May 10, 2019

**Re: McDonalds - 8315 Montgomery Blvd NE
Tract A-1-F of the Los Pastores Shopping Center
Grading and Drainage Plan - Engineer's Stamp date 4/4/2019 (F19D013A)**

Based on the application received 5/9/2019, the above referenced plan cannot be approved for building permit until the following comments are addressed.

C8.1

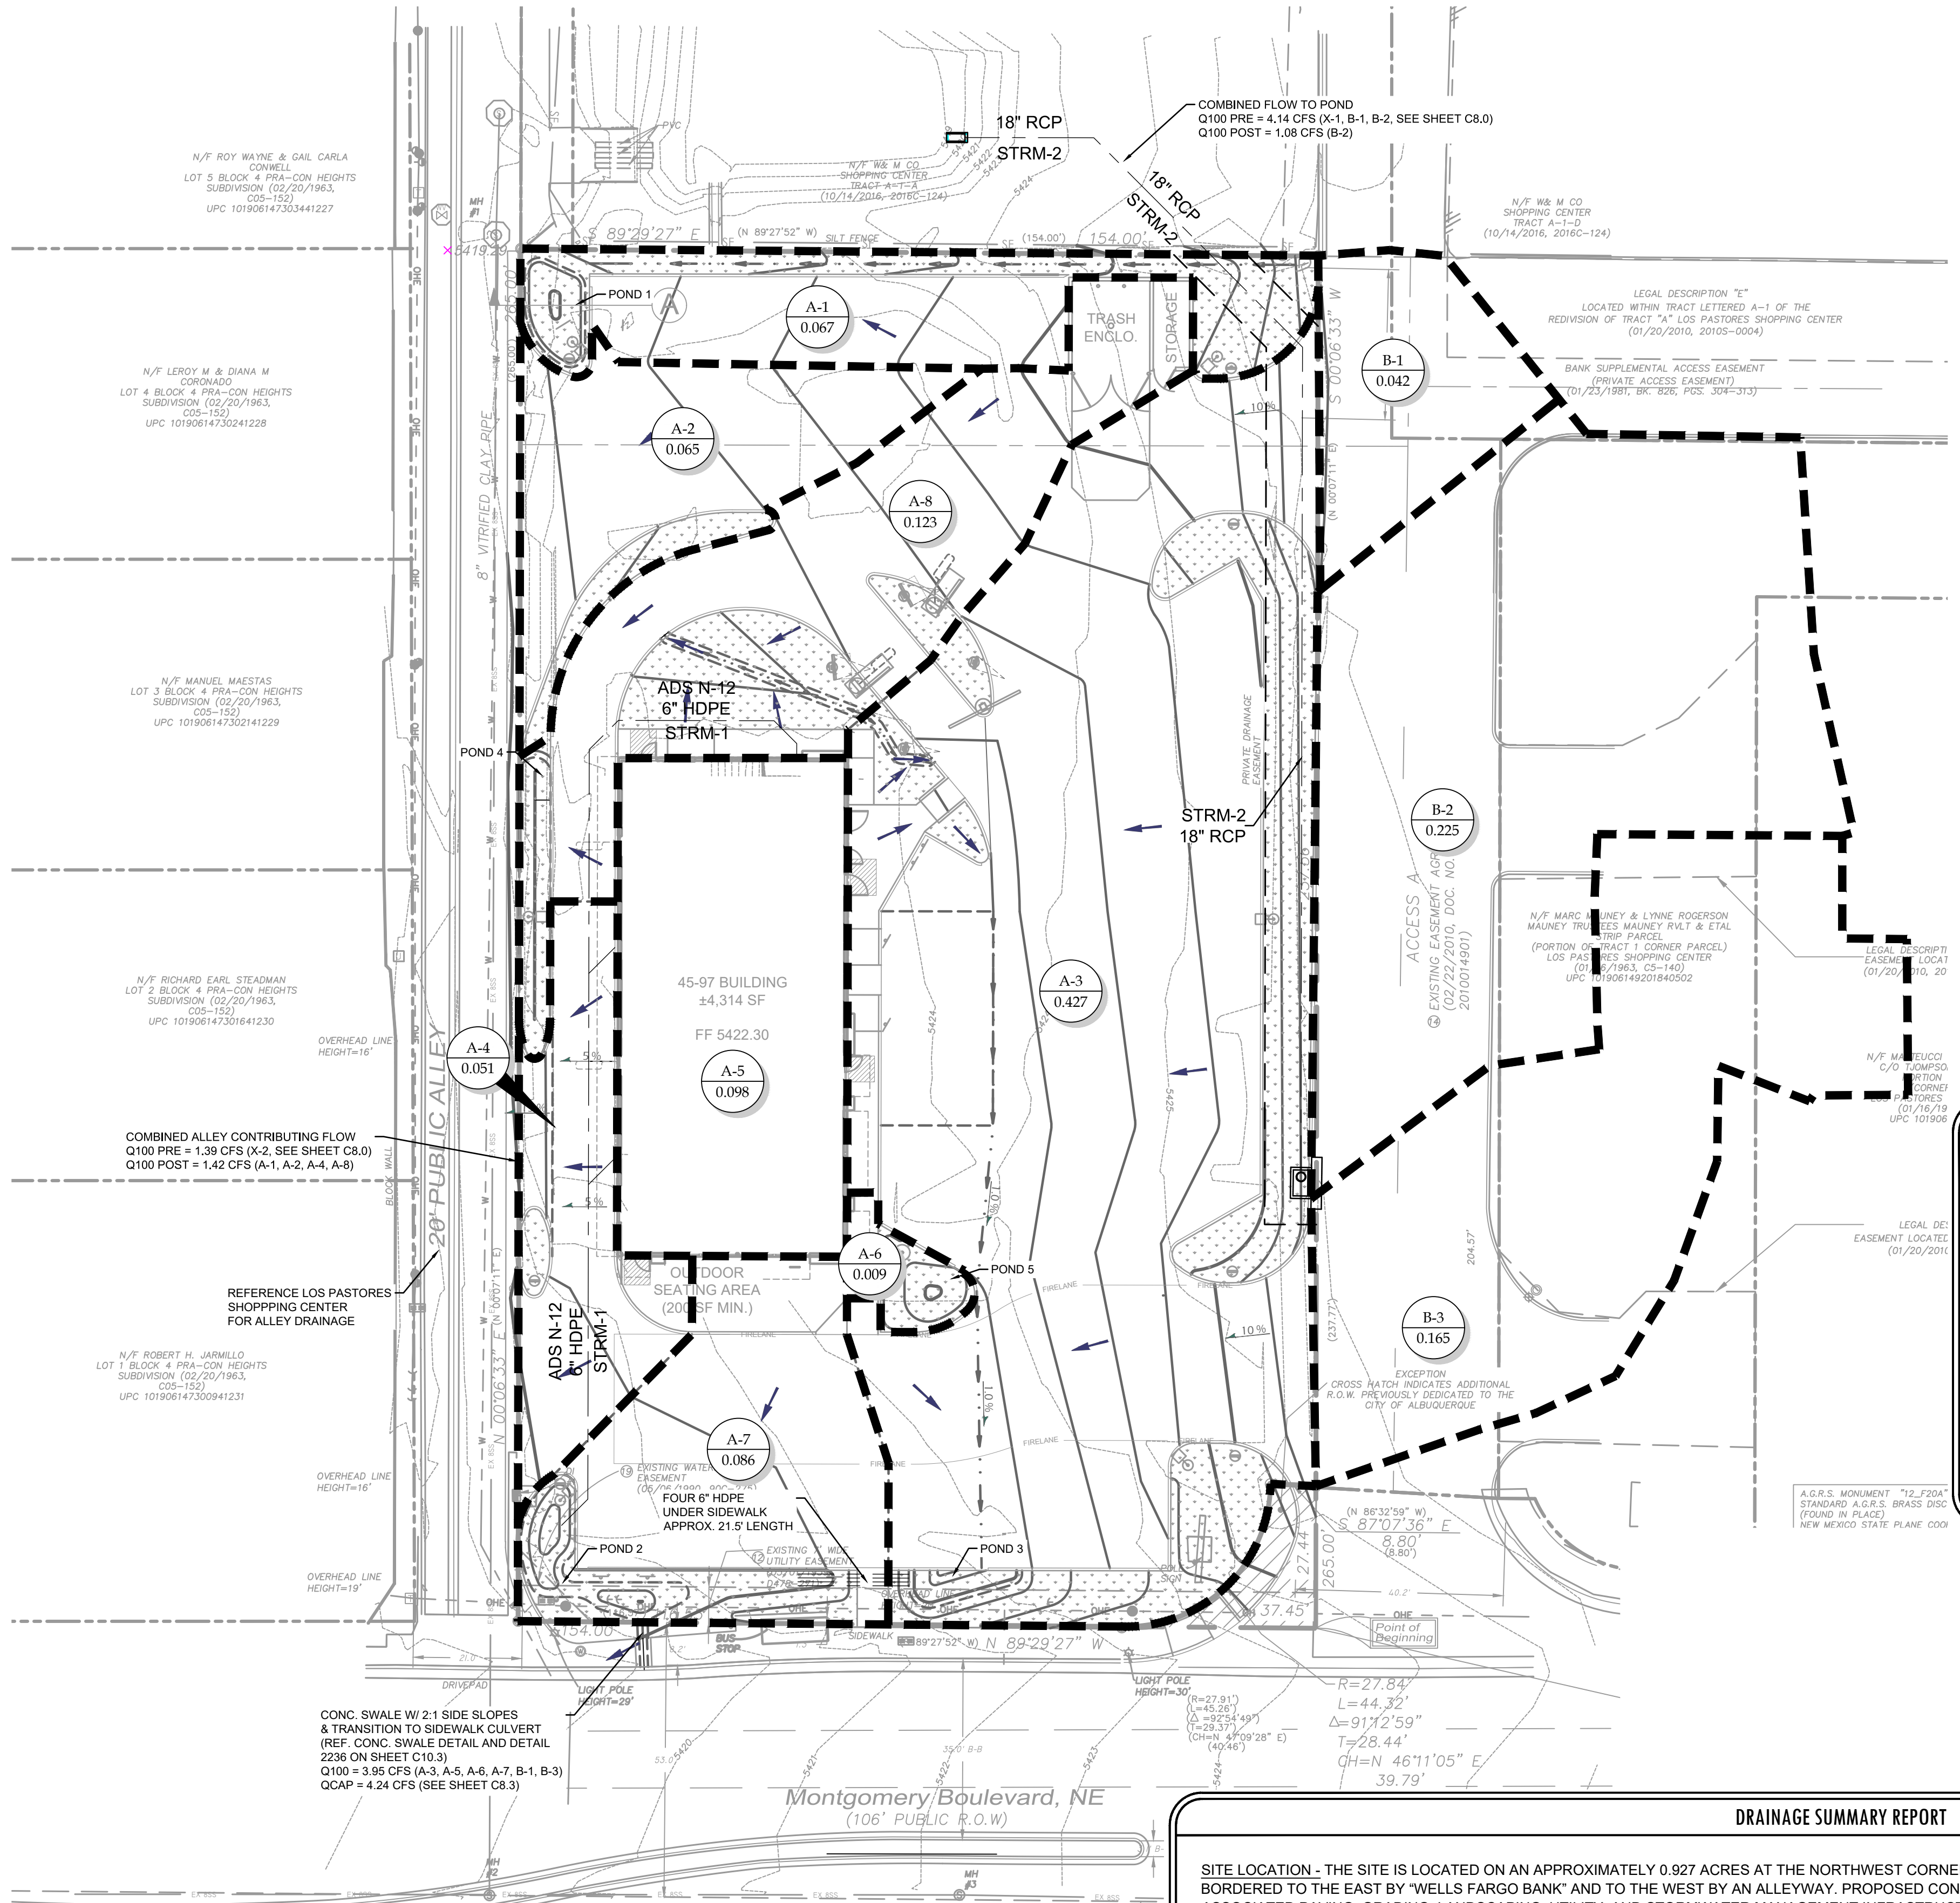
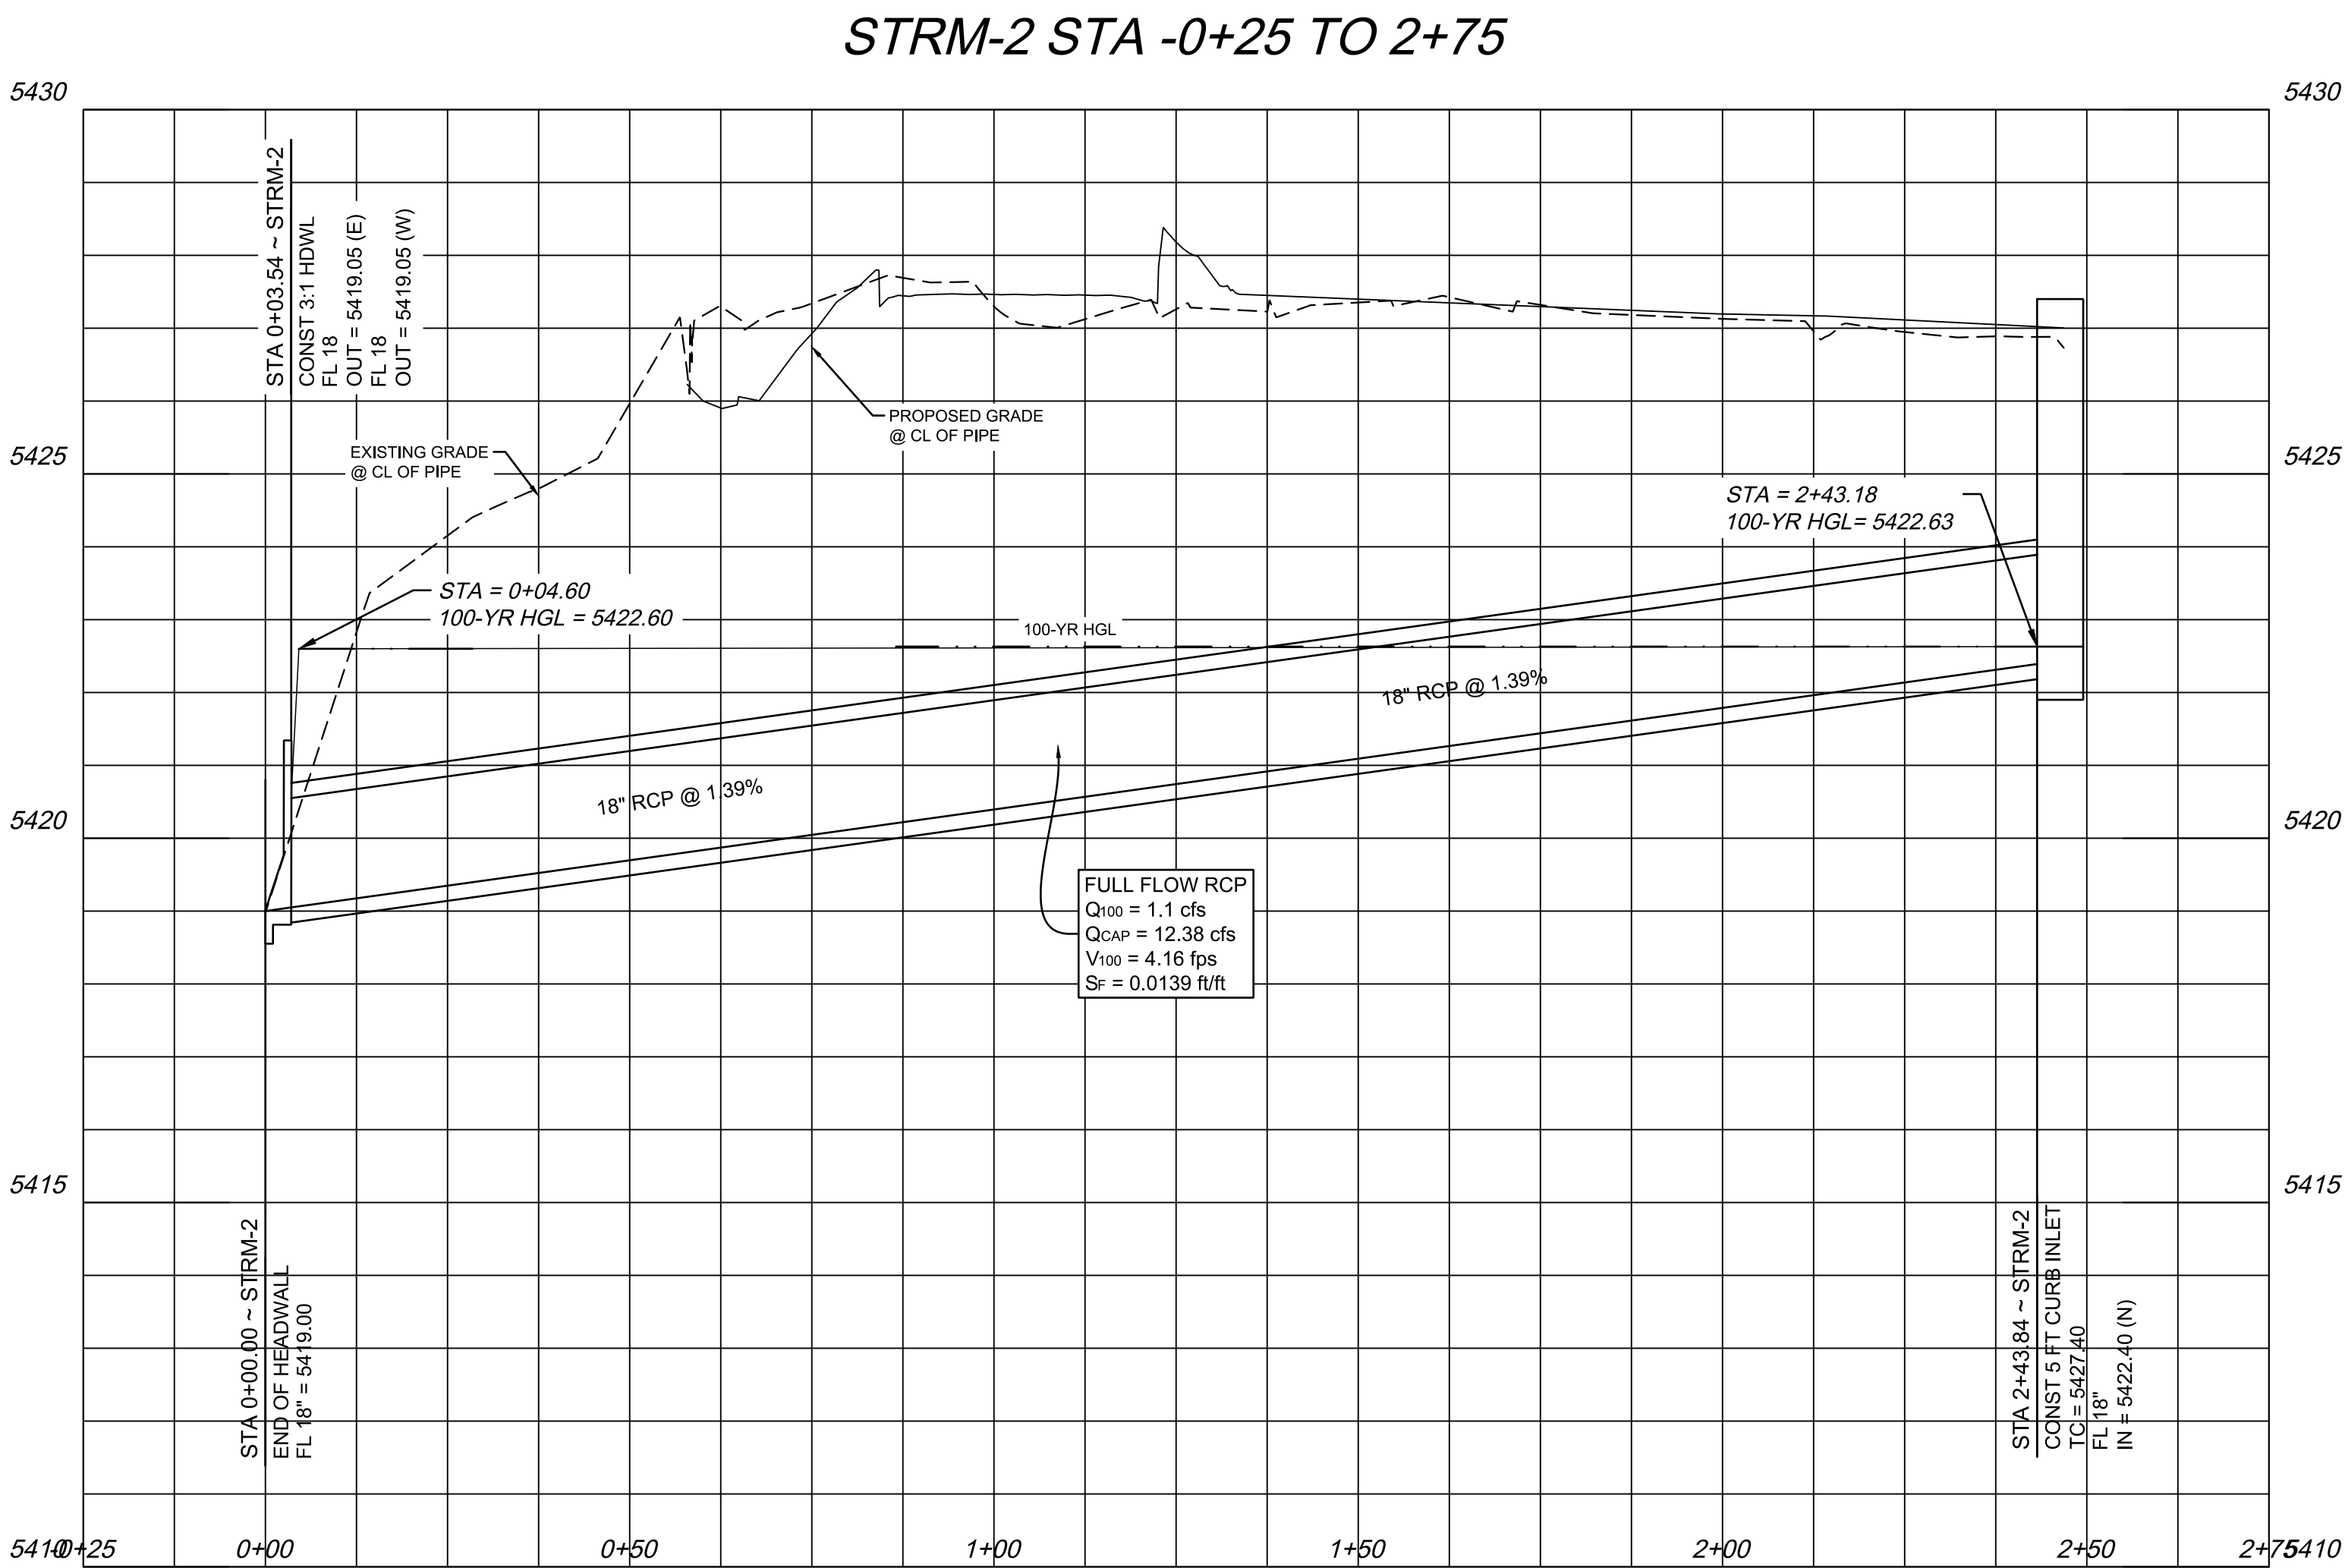
1. Please state the Drainage Management Plan for this site (ie. Retention, Detention, or Free Discharge). The "Conclusion" on sheet C8.1 is a misstatement of the pertinent facts and should be replaced with "Drainage Management Plan – This site will drain in accordance with the Los Pastores Shopping Center DMP with engineers stamp date 5/2/2019 which includes a combination of Free Discharge and Detention. The other statements in the "Conclusion are not pertinent and should be deleted.

2. The flow rates shown along the alley do not agree with the Los Pastores Shopping Center DMP. It is not necessary for this development to duplicate the flow rates that are identified in that DMP, but if the flow rates are going to be called out on Sheet C8.1 then they must agree with the DMP.

3. Please change "Bio-retention (0.34)" to "Redevelopment SWQV (0.26)" in the "Proposed Conditions" Paragraph on sheet C8.1.
4. The plan must clearly identify how the Stormwater Quality Volume (SWQV) requirements are being met. If the response to comments letter, which says "It is McDonald's desire to provide payment in lieu of the total required storage volume", is correct, then please add that statement to the plan including the specific area of impervious not served by onsite BMPs and the volume associated with the Payment in Lieu of Construction.

5. Ponds #1 and #4 appear to have been deleted from the plan, Sheet C8.1 or are not labeled. If so, please delete the Stage Storage Volume table from sheet C8.2 for those two ponds. Also delete them from the "Pond FF Elevation Table" on that sheet. The second table titled "First Flush Volume Calculations" should look more like the one below using the volumes from the "Stage Storage Volume" tables.
